Re: SSD 8373 - Park Rd, Alexandria - Alexandria Park Community School Redevelopment.

This letter is Ausgrid's response under clause 45(2) of the State Environmental planning Policy (Infrastructure) 2007.

- AR-DA-1101 Proposed Site Plan Rev.P3
- AR-DA-3001 Elevations and Sections Rev.P3

Drawing Title
PROPOSED SITE PLAN

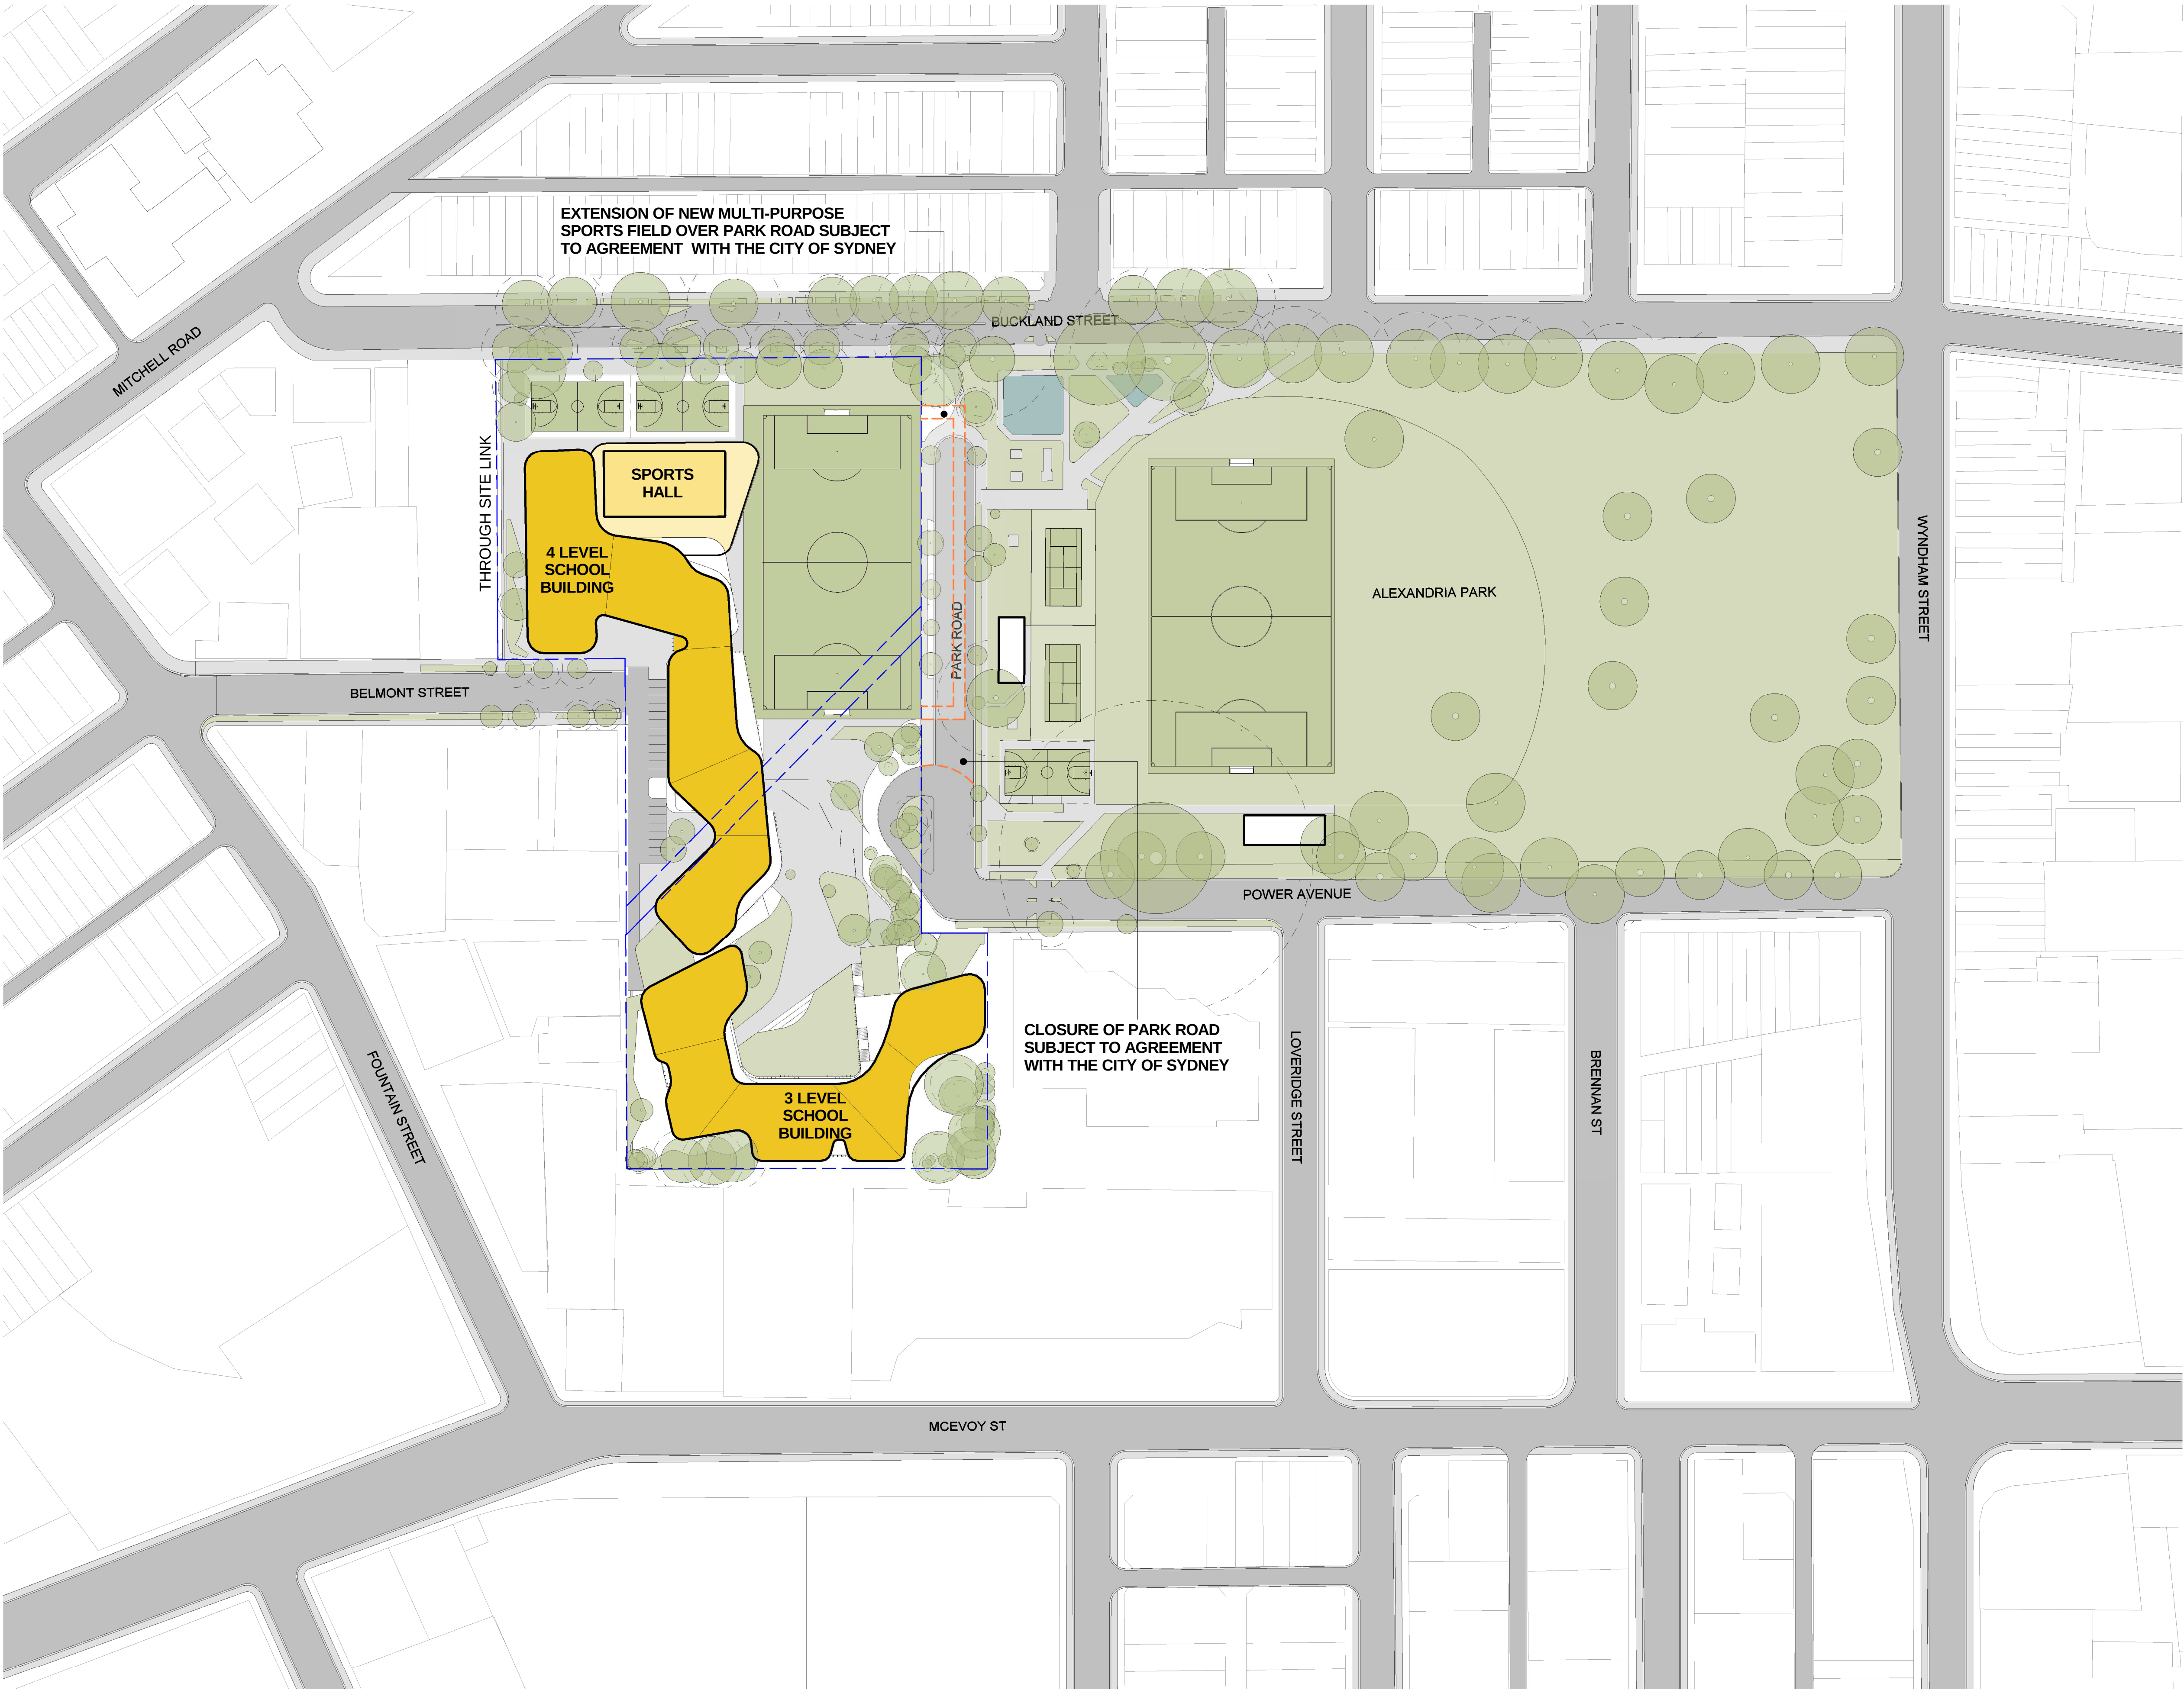
There are existing overhead electricity network assets in Park Rd, Power Ave and Buckland St.

With regard to the proposed road closure, particular consideration will need to be given to the overhead powerlines in Park Rd to ensure Ausgrid's operational and maintenance needs are met. Should a legal closure of the road be required, the developer will be required to ensure a suitable easement is created to protect the overhead powerlines. Such an easement must meet the requirements of Ausgrid Standard NS143.

Based on the design of the development provided, it is expected that the "as constructed" minimum clearances will not be encroached by the building development. However it remains the responsibility of the developer and relevant contractors to verify and maintain these clearances onsite.

It is also the responsibility of the developer to ensure that the existing overhead mains have sufficient clearance from all types of vehicles that are expected be entering and leaving the site.

There are existing underground electricity network assets in Park Rd, Power Ave and Buckland St.

With regard to the proposed road closure, particular consideration will need to be given to the electricity cables in Park Rd to ensure Ausgrid's operational and maintenance needs are met. Should a legal closure of the road be required, the developer will be required to ensure a suitable easement is created to protect the existing cables and any future electricity network development which may be required. Such an easement must meet the requirements of Ausgrid Standard NS143.

Special care should also be taken to ensure that driveways and any other construction activities within the footpath area do not interfere with the existing cables in the footpath. Ausgrid cannot guarantee the depth of cables due to possible changes in ground levels from previous activities after the cables were installed. Hence it is recommended that the developer locate and record the depth of all known underground services prior to any excavation in the area.

There are existing electricity substation assets on the subject site (S77856) adjacent to Buckland St.

In addition to above, Ausgrid requires the substation ventilation openings, including duct openings and louvered panels, to be separated from building ventilation system air intake and exhaust openings, including those on buildings on adjacent allotments, by not less than 6 metres.

Any portion of a building other than a BCA class 10a structure constructed from non combustible materials, which is not sheltered by a non-ignitable blast-resisting barrier and is within 3 metres in any direction from the housing of a kiosk substation, is required to have a Fire Resistance Level (FRL) of not less than 120/120/120. Openable or fixed windows or glass blockwork or similar, irrespective of their fire rating, are not permitted within 3 metres in any direction from the housing of a kiosk substation, unless they are sheltered by a non-ignitable blast resisting barrier.

1 NORTH ELEVATION
1 : 500

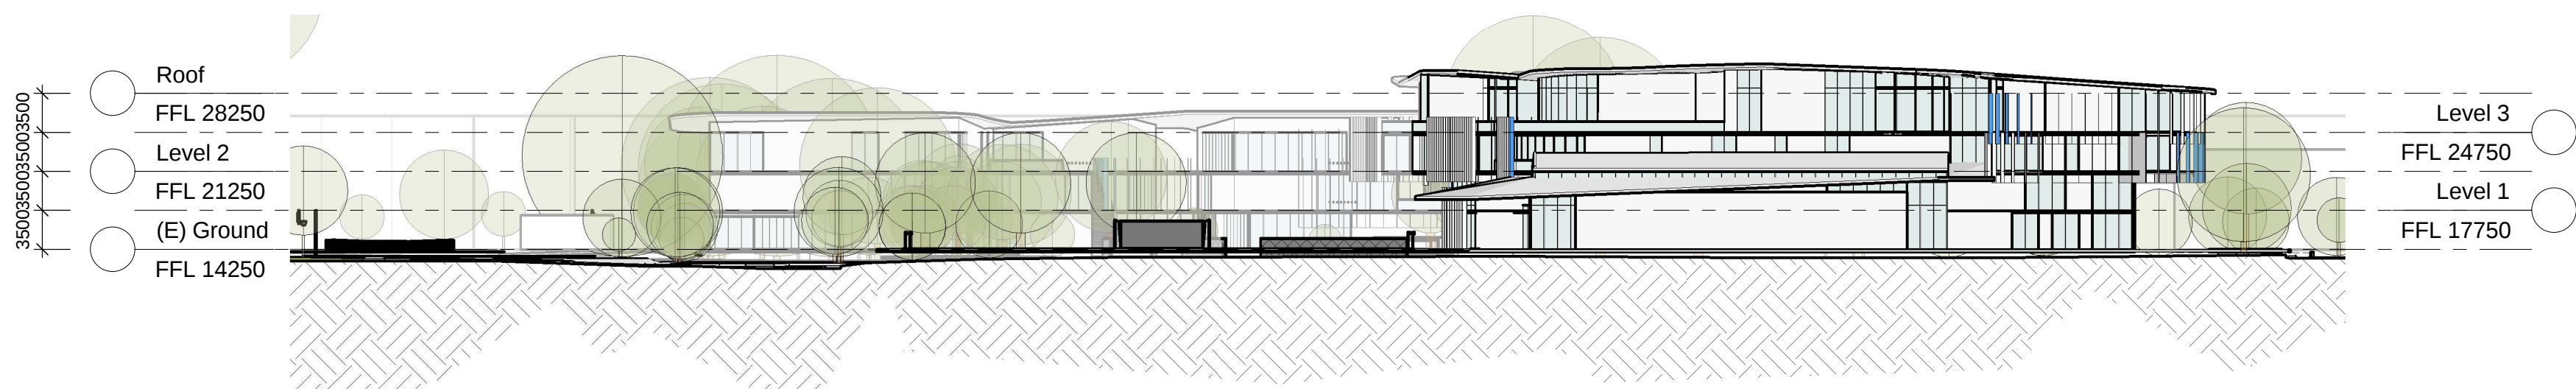
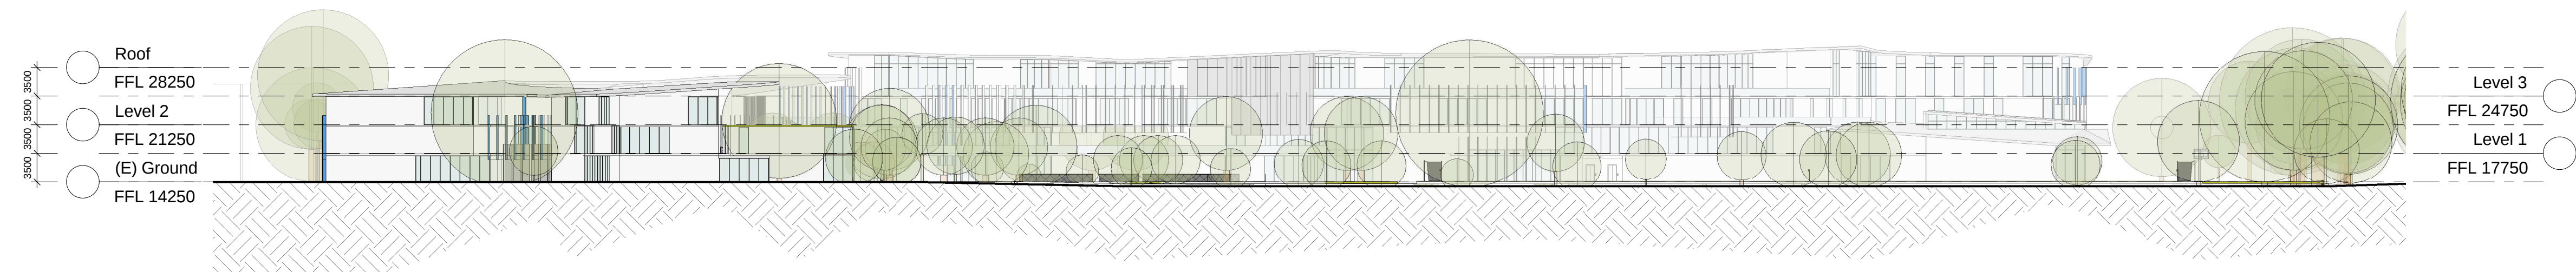
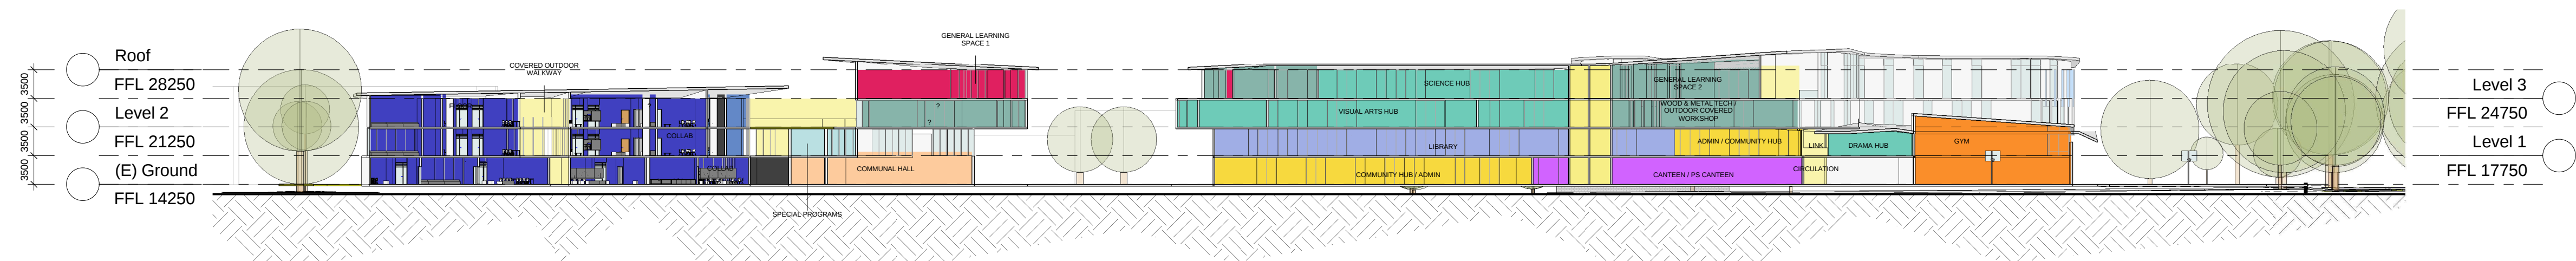
The "as constructed" minimum clearances to the mains should also be considered. These distances are outlined in the Ausgrid Network Standard, NS220 Overhead Design Manual. This document can be sourced from Ausgrid's website, www.ausgrid.com.au
